Please ask for: Mrs D Johnson
Email: daun.johnson@arun.gov.uk
Telephone: 01903 737762
Our Ref: EP/69/21/PL
Your Ref:
Date: 14th June 2021

Application for Planning Permission

Development: 1 No. 3-bed bungalow (resubmission following EP/10/21/PL). This site is in CIL Zone 4 & is CIL Liable as new dwelling.
Location: 4 Beechlands Close And Land East Of 18 Montpelier Road East Preston BN16 1JZ

SIDE ELEVATION

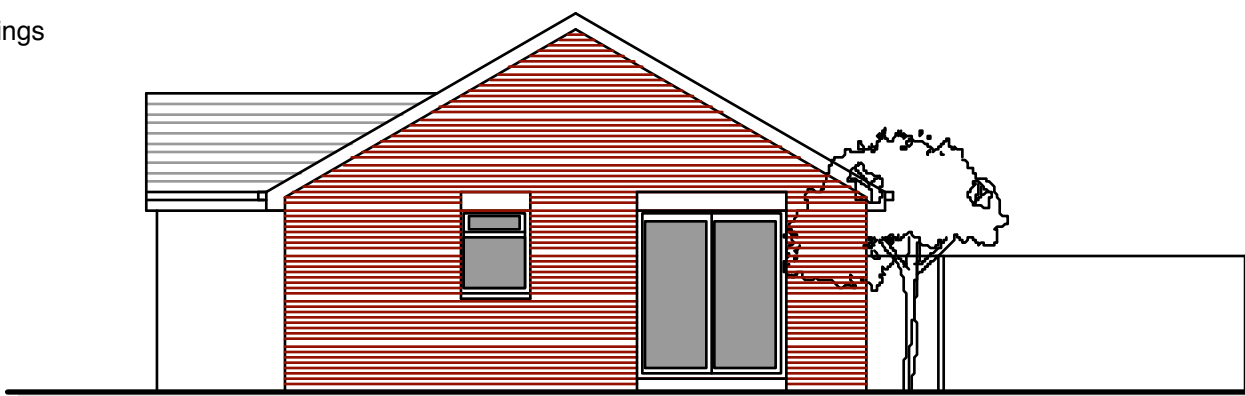
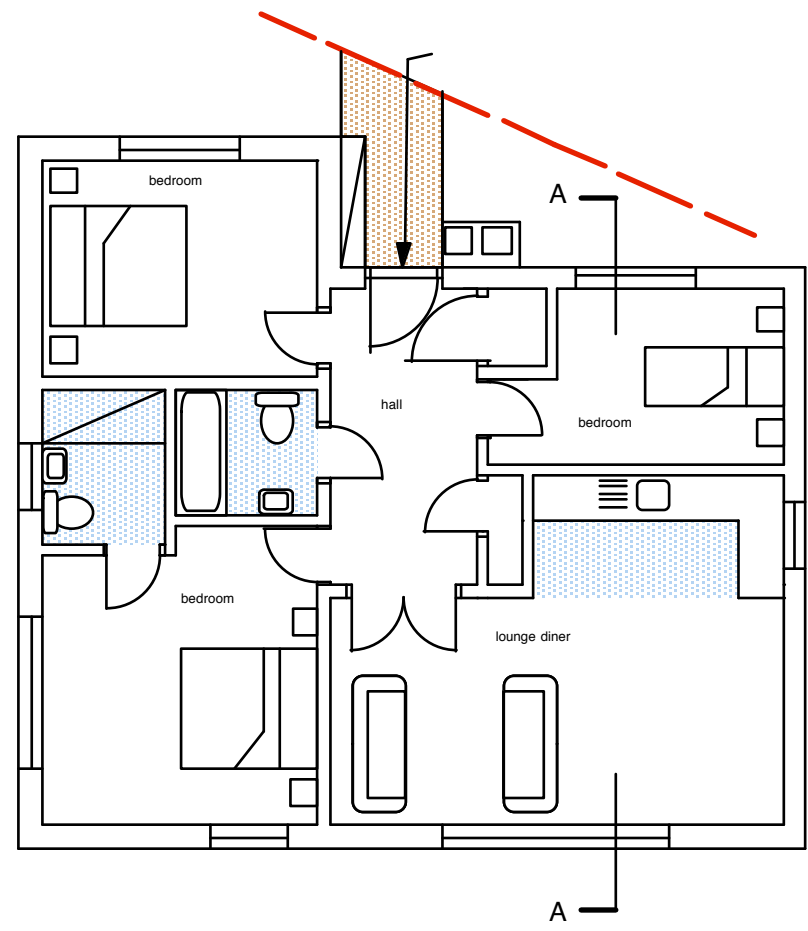
The proposed side elevation and ground floor plan do not accord. Please amend accordingly.
